TOWN AND COUNTRY PLANNING ACT 1990

FULL

Reference:	H14-0205-18	Date of Decision:	1st May 2018
Applicant:	Ms T Rodgers Claydon North Drove Spalding Lincs PE11 3JF		
Location:	Claydon North Drove Spalding		
Description:	Proposed one-and-a-half storey dwelling

FIRST FLOOR PLAN

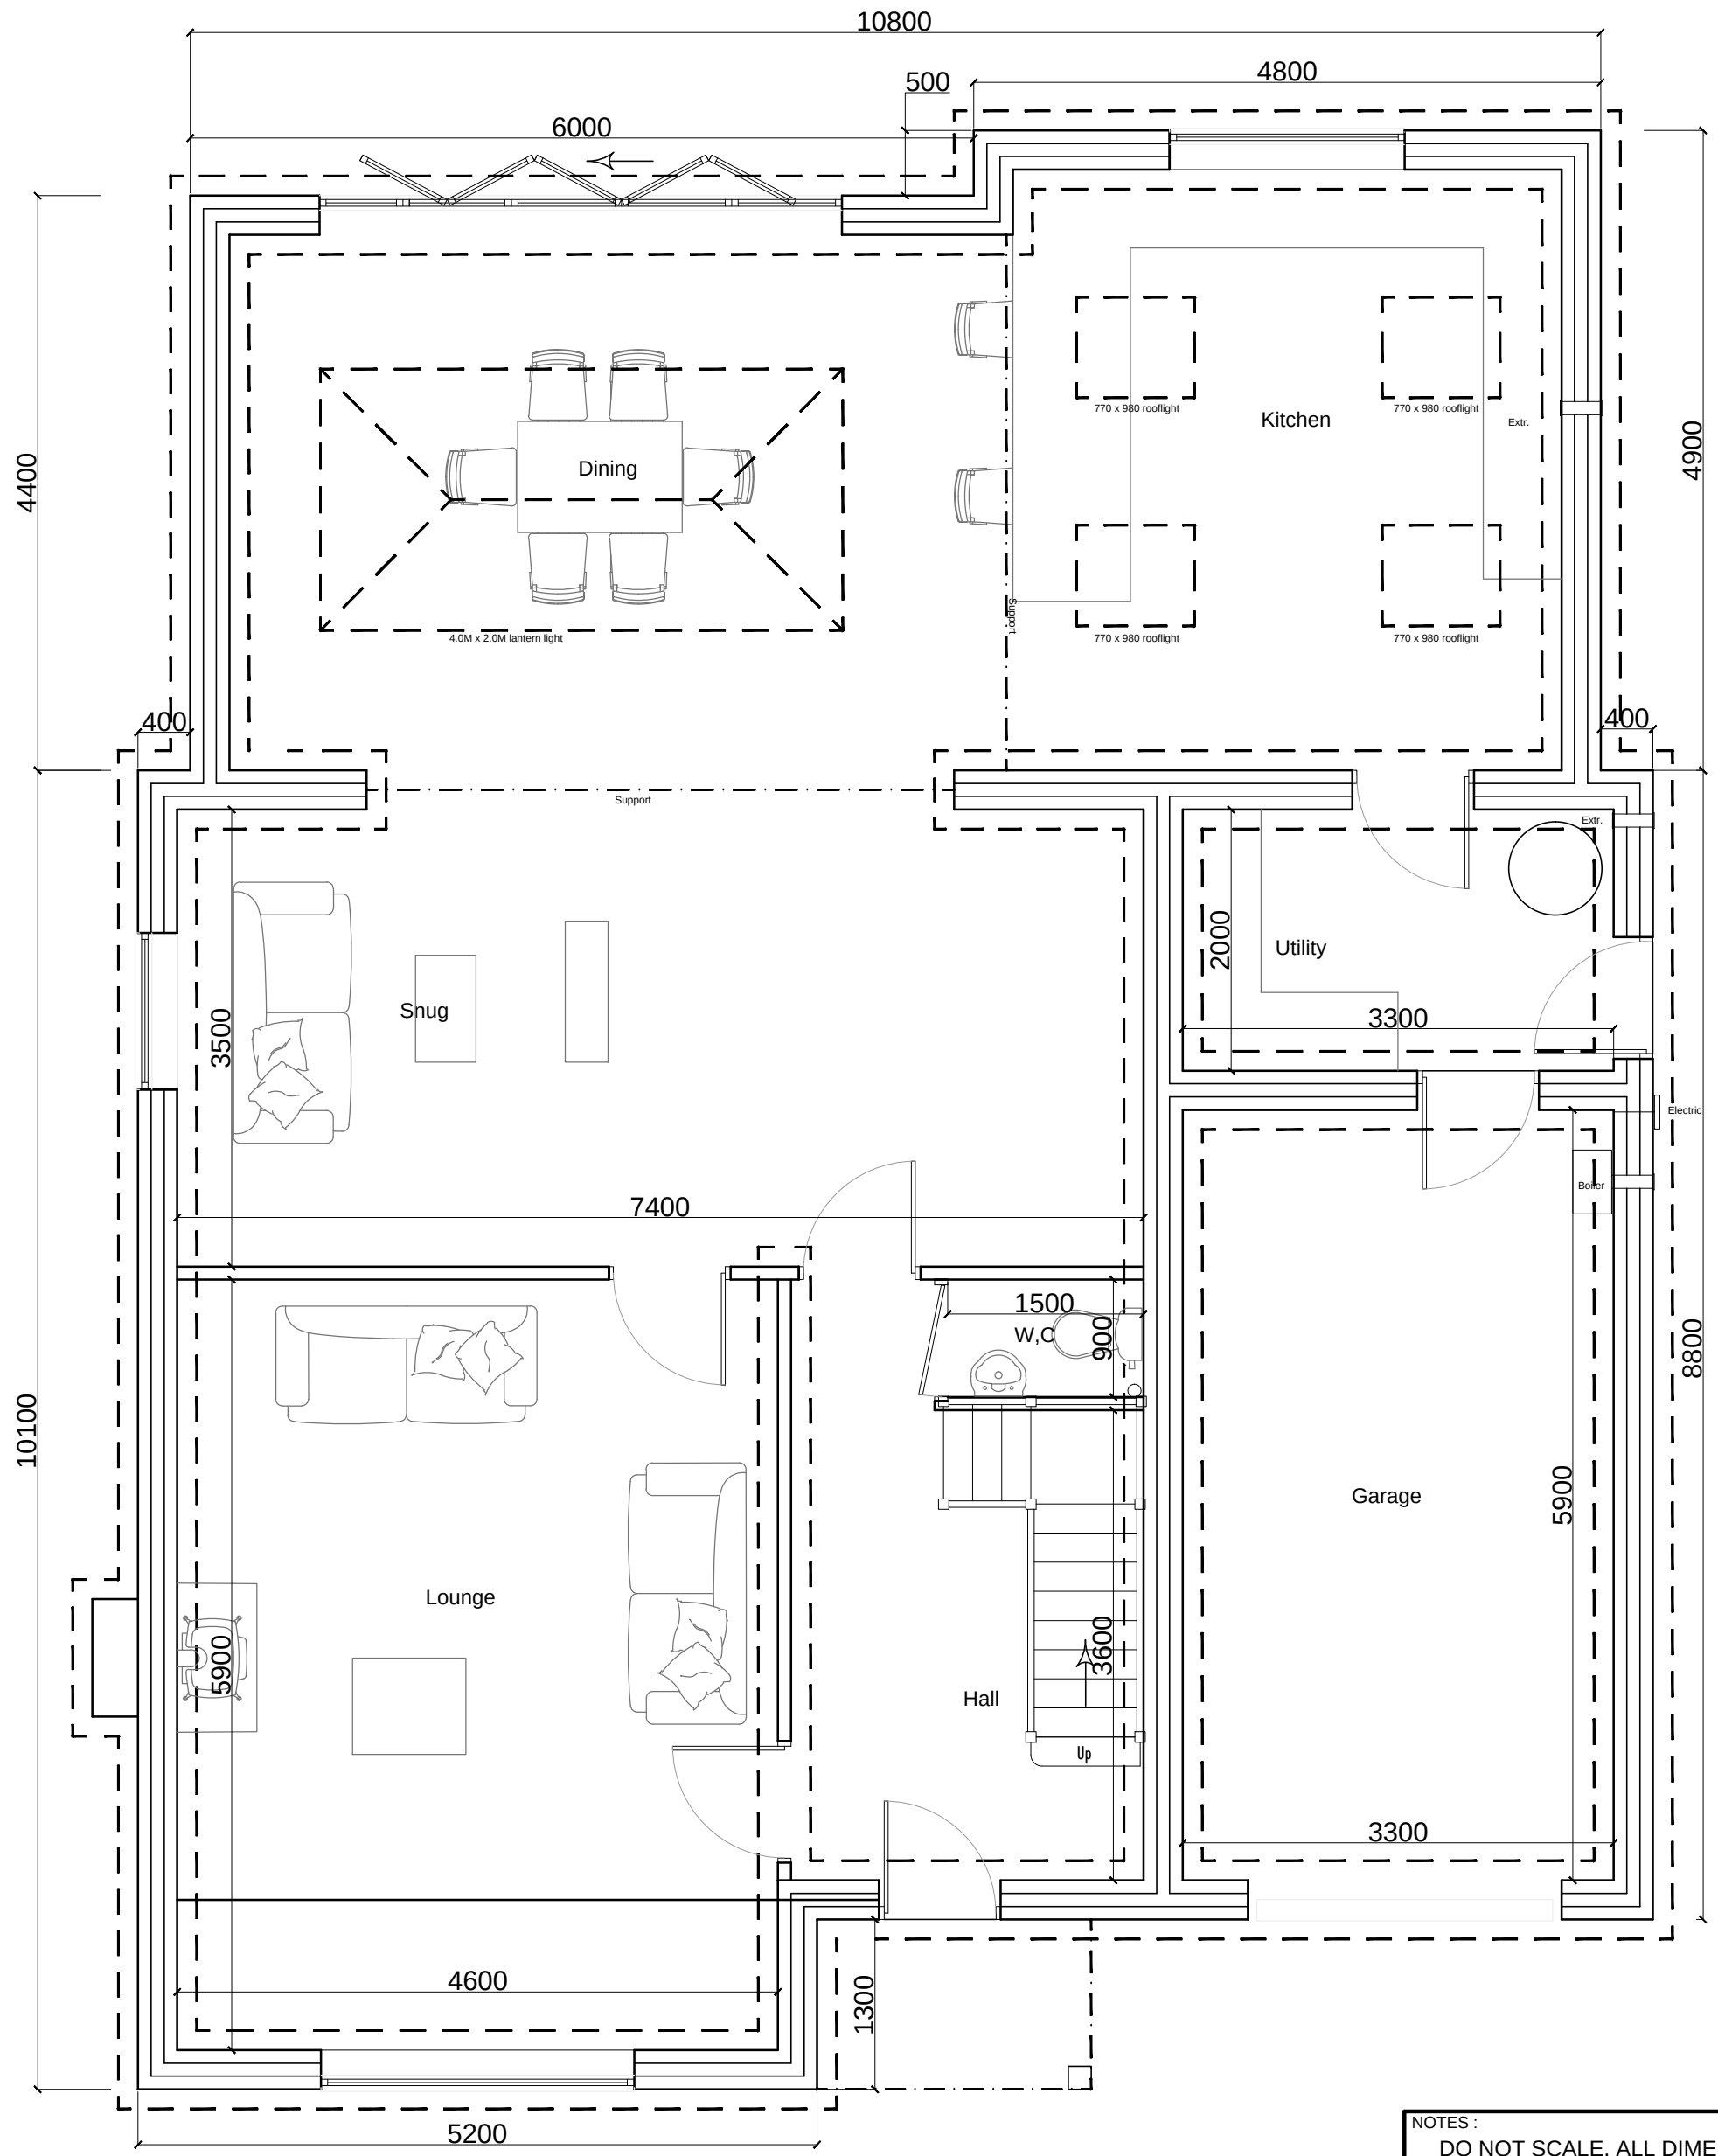
- 2 The proposed development is considered to be a cramped form of development which is at odds with the character of existing development in the locality.
